| <b>Consultation Response from KC,<br/>Lead Local Flood Authority</b>                                                                                                                |
| <b>2025/90659 Land at, Blue Hills Farm, Whitehall Road West, Birkenshaw, BD11 2DU</b>                                                                                               |
| <b>Discharge of details reserved by condition 10 (foul and surface water drainage) on outline permission 2019/90527 for erection of up to 127 dwellings, with details of access</b> |
| <b>Date Responded: 28<sup>th</sup> March 2025</b>                                                                                                                                   |

S104 Impermeable Area Plan

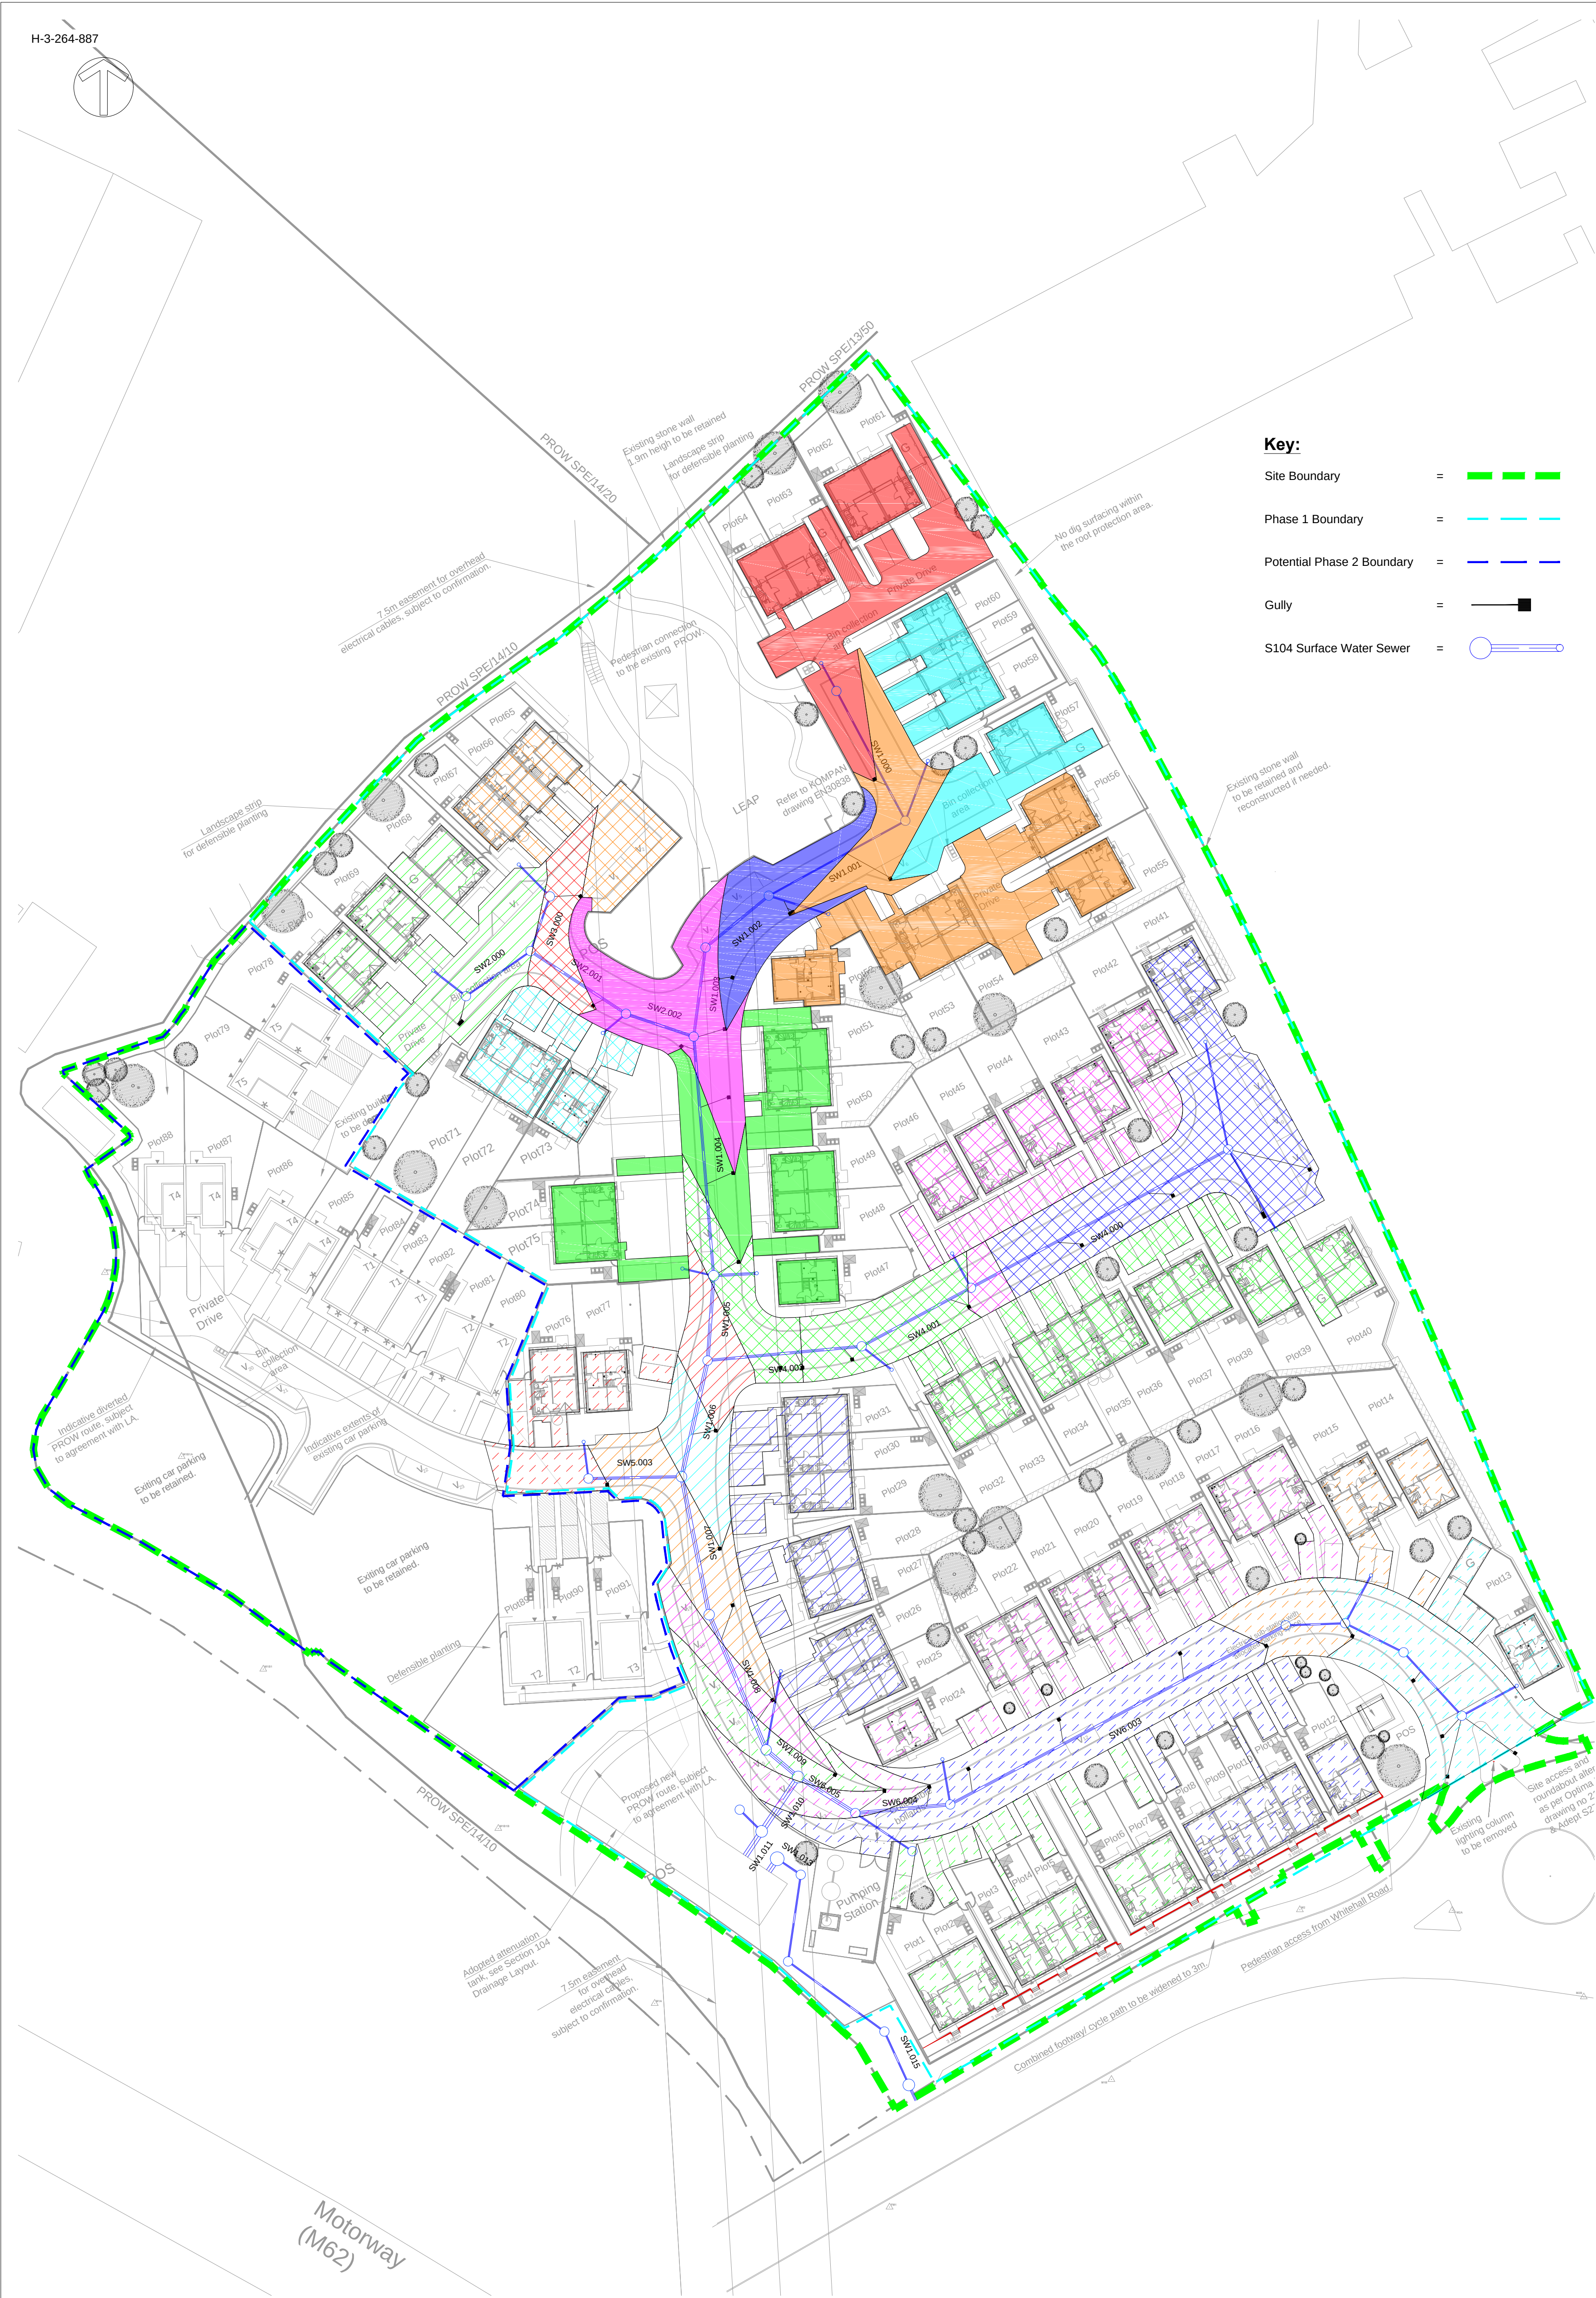
Please supply a plan showing areas of hardstanding contributing to each sewer leg.

Please supply hydraulic simulation sheets cross referenced to the contributing hardstanding drawing to demonstrate no flooding for the design.
